Department
for Transport

PLANNING ACT 2008

APPLICATION FOR THE PROPOSED HINCKLEY RAIL FREIGHT INTERCHANGE DEVELOPMENT CONSENT ORDER

**WORK No.7 A47 LINK ROAD ACOUSTIC FENCE LOCATION GABION WALL OPTION**

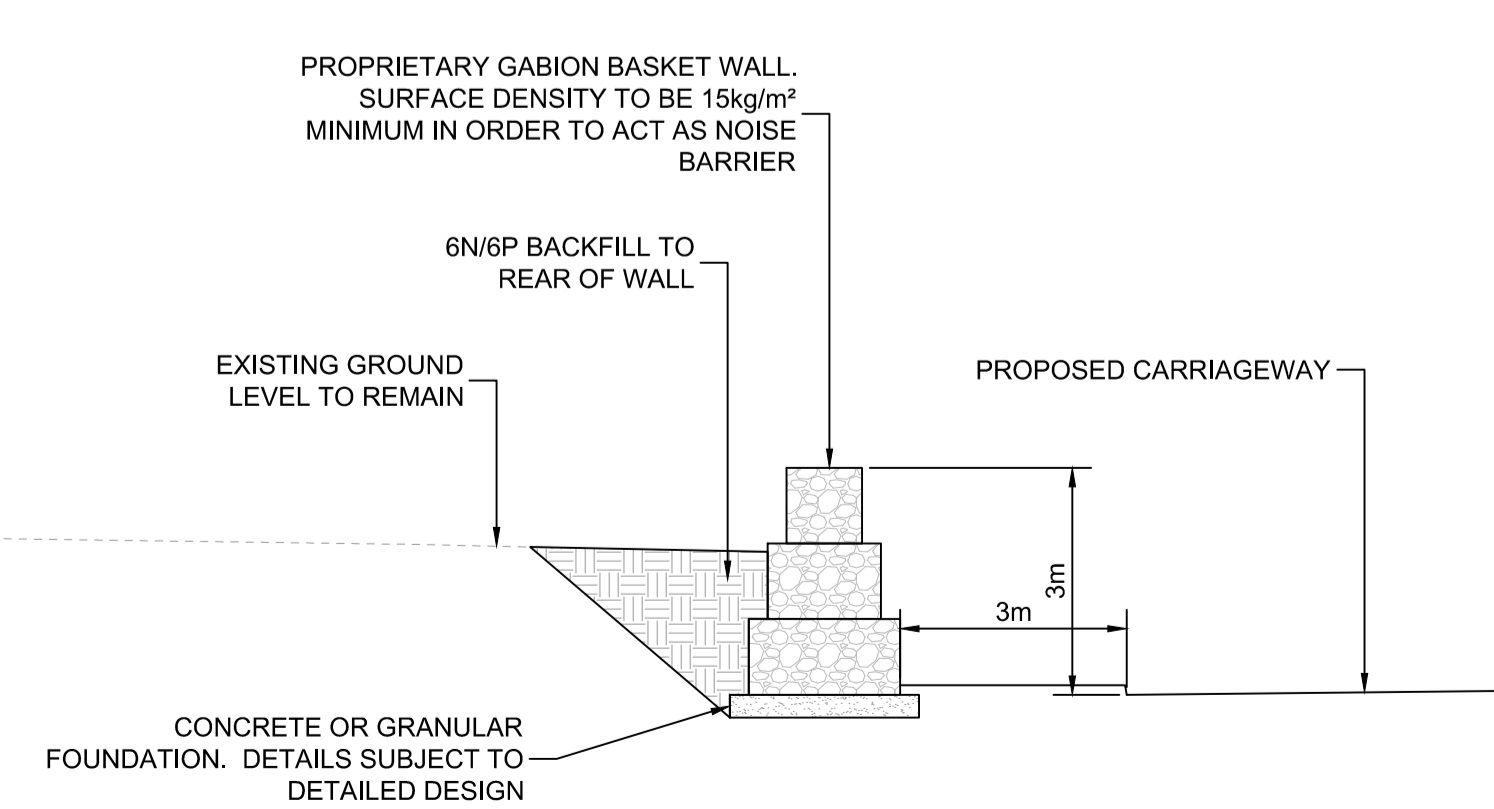
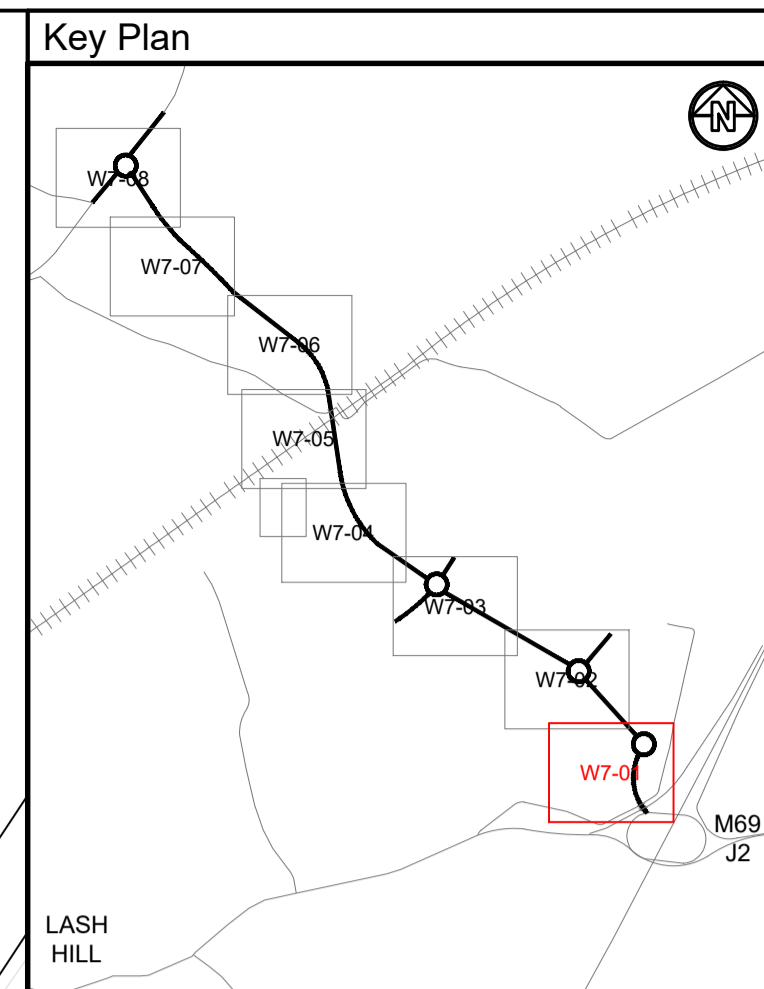
23. The ExA concluded that the proposed 6-metre high noise barrier to be located along the south-eastern boundary of the site of the Proposed Development would result in a visually dominant and oppressive fence for a small number of the residential units located at the Aston Firs travellers site. The ExA concluded that this would have a considerable detrimental impact on the living conditions and mental health of those residents [ER 3.6.74 – 3.75 and 3.6.81, point 5]. The ExA also concluded that these impacts would result in discrimination of race as defined by the Equality Act 2010 and would result in the segregation of the residents of the Aston Firs Travellers Site from the surrounding local community [ER 3.6.79 and 5.4.11].

27. While both councils responded to confirm that they welcome the changes proposed to the 6-metre-high noise barrier, they also raised concerns regarding the impact of the 4-metre-high barrier at the northern site boundary. They state that this barrier would continue to be an unsightly and inhospitable boundary for the Aston Firs residents as well as being visually unattractive to wider views from beyond the fence from the eastern side of Freeholt Wood. The Secretary of State also notes that they raised concerns about the lack of detail on the management of the new 12 metre buffer zone.

- provision for a buffer zone of at least 12 metres between the acoustic barrier and the site boundary;
- redesign of the barrier at the southeastern boundary to reduce the height from 6 metres to 3 metres;

- provision for the realignment of the Public Right of Way and amended landscaping in the area; and
- provision for the use of a Gabion wall to provide an equivalent acoustic barrier of the same finished height and acoustic specification.

28. The Secretary of State welcomes the changes proposed by the Applicant to help resolve the impact from the noise barriers at the south-eastern boundary, including the addition to Requirement 4(2)(v) proposed in the 3 March representation. She also agrees with the Applicant that the ExA should have given more prominence to this issue during the Examination given its views on the severity of the impacts and the implications for the Public Sector Equality Duty in order to allow the Applicant to address these issues earlier.

29. The Secretary of State considers that the Applicant's proposed changes reduce impacts on the residents of the Aston Firs travellers site to an acceptable level and that due regard has been paid to the needs identified in the Public Sector Equality Duty. She also notes the concerns raised by HBBC and BDC on the 4m barrier that remains along the north western boundary of the site. However, she remains in agreement with the ExA that the 4m barrier along the north-western boundary would not appear unduly oppressive [ER 3.6.73].
